FALL MOUNTAIN FARM
16300 MOUNT HERMAN LANE
MONUMENT, CO 80132
PRELIMINARY LANDSCAPE PLAN

SHEET TITLE:
LANDSCAPE PLAN

Landscape Plan Drawings_V1.pdf Markup Summary

SHEET TITLE:  
**LANDSCAPE PLAN**

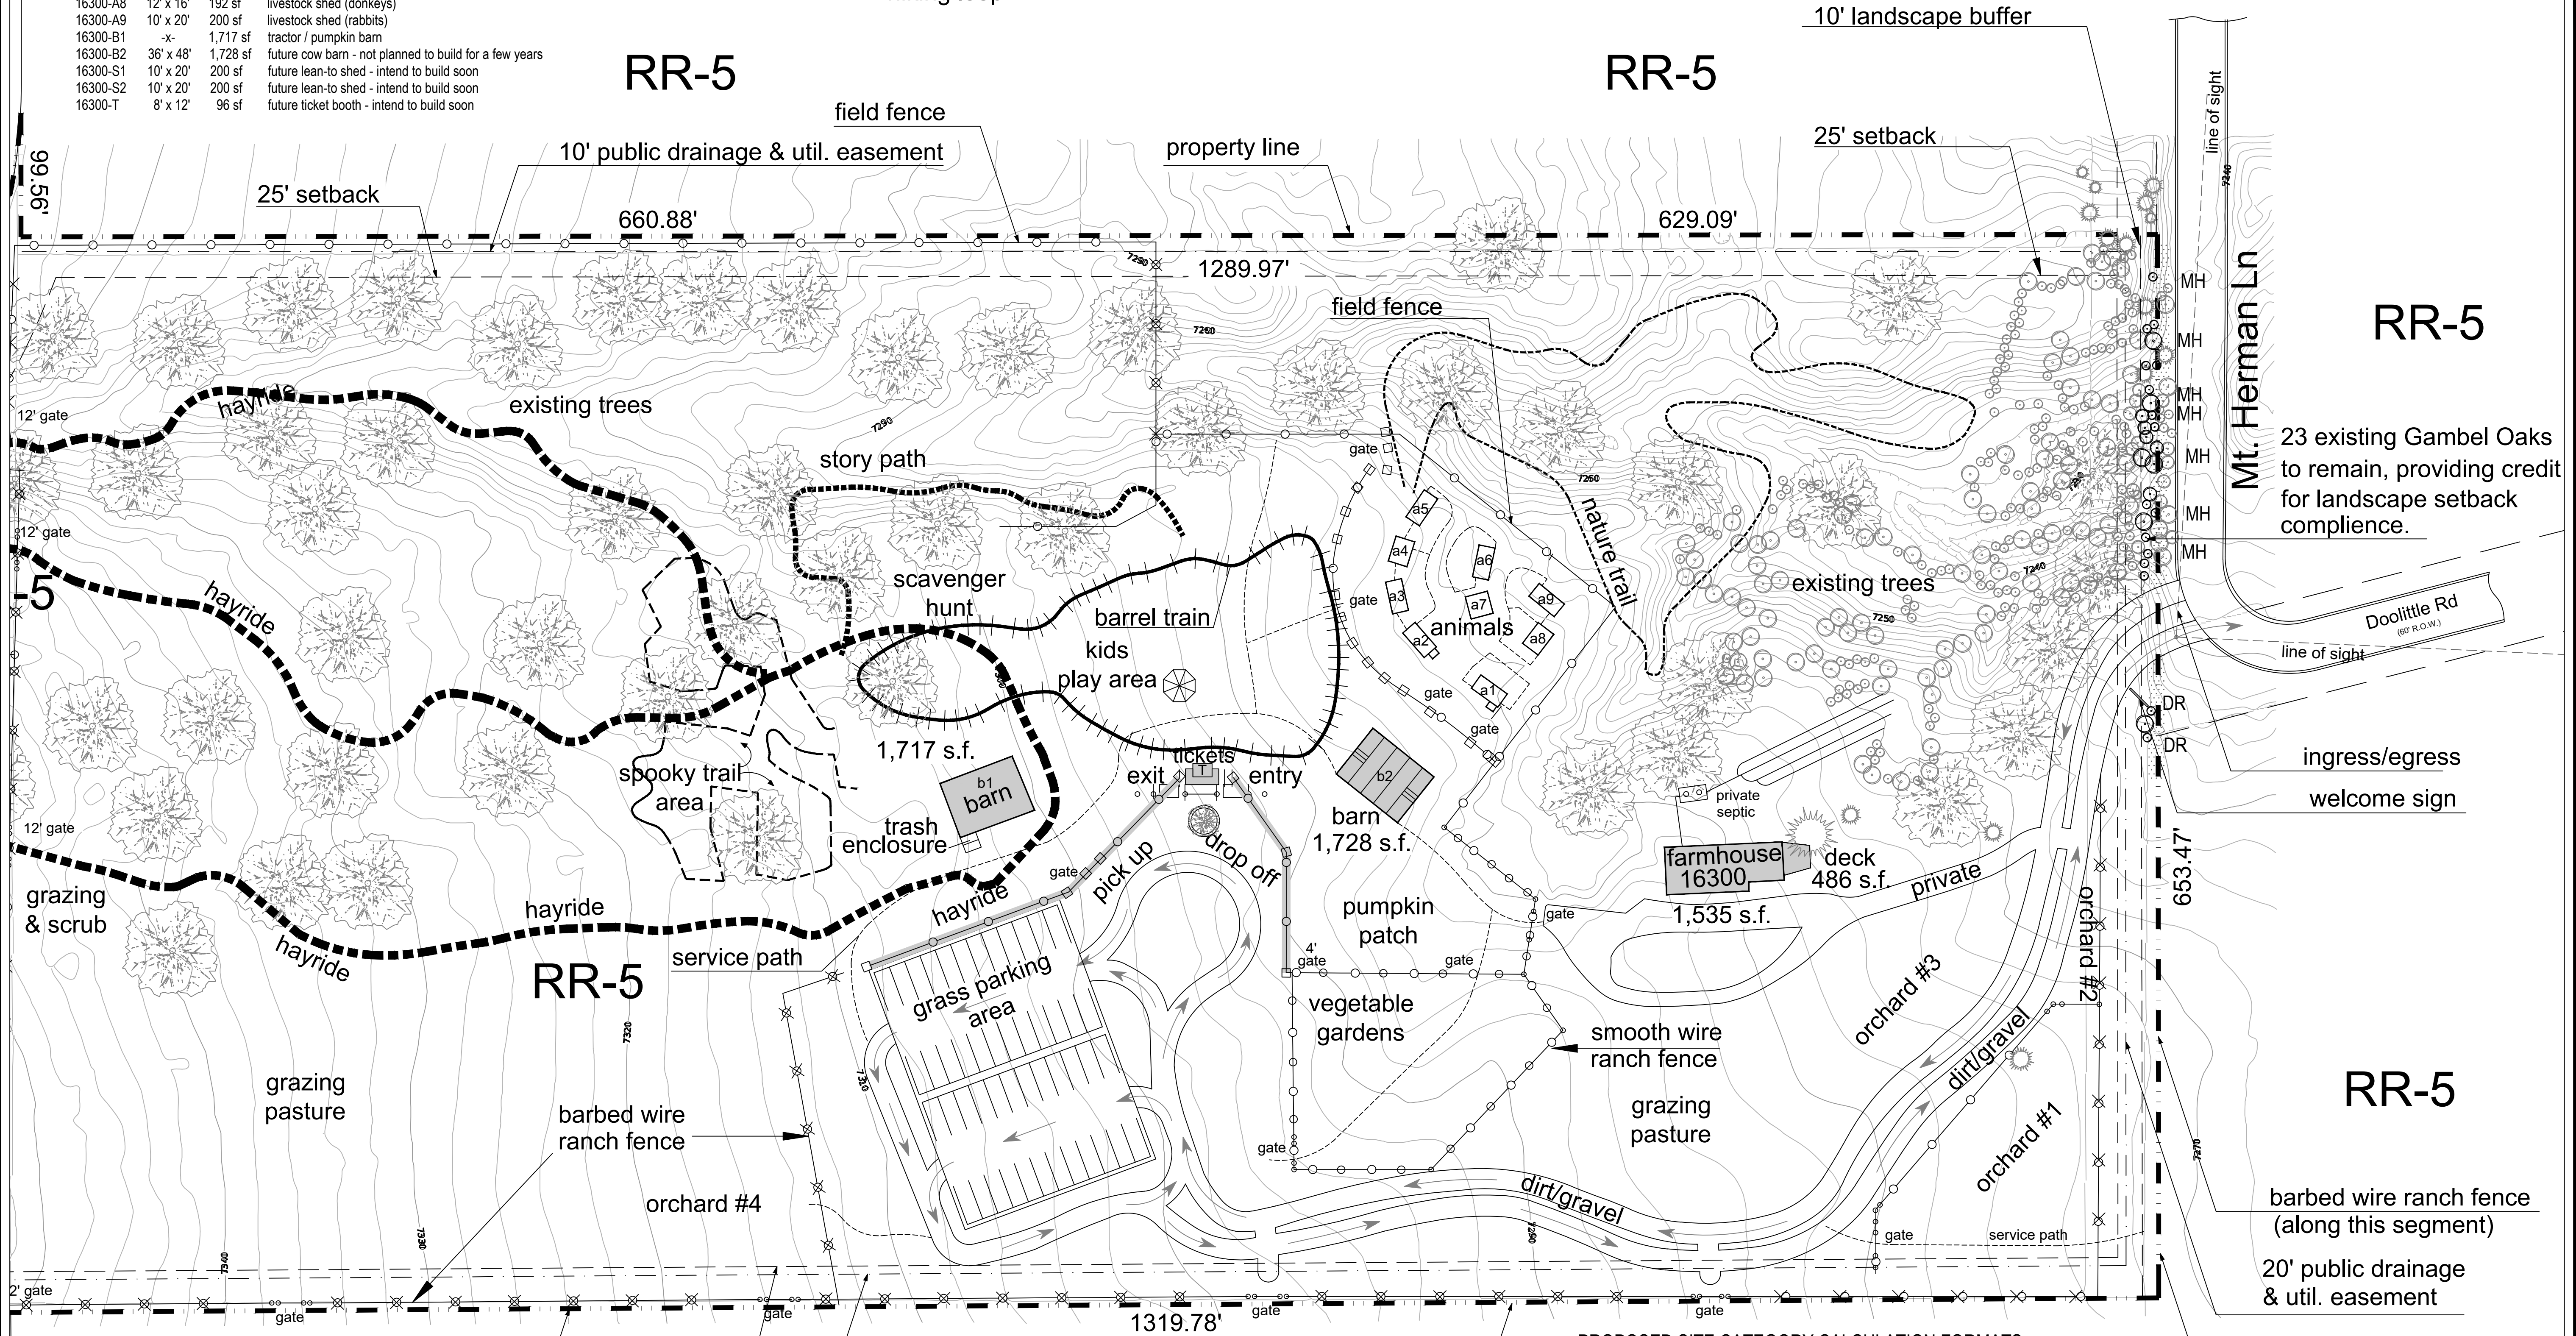
Per plat map 8287; 1319.78

Show on plan:
The location of all utilities, walls, fences, exterior parking and loading areas, pedestrian walks or paths, pedestrianoriented areas, vehicular drives, storm water detention areas, and other manmade elements. Detail drawings of all required structures used for screening purposes (Example: refuse areas, equipment screening, and/or gates)

Verify property all line dimensions
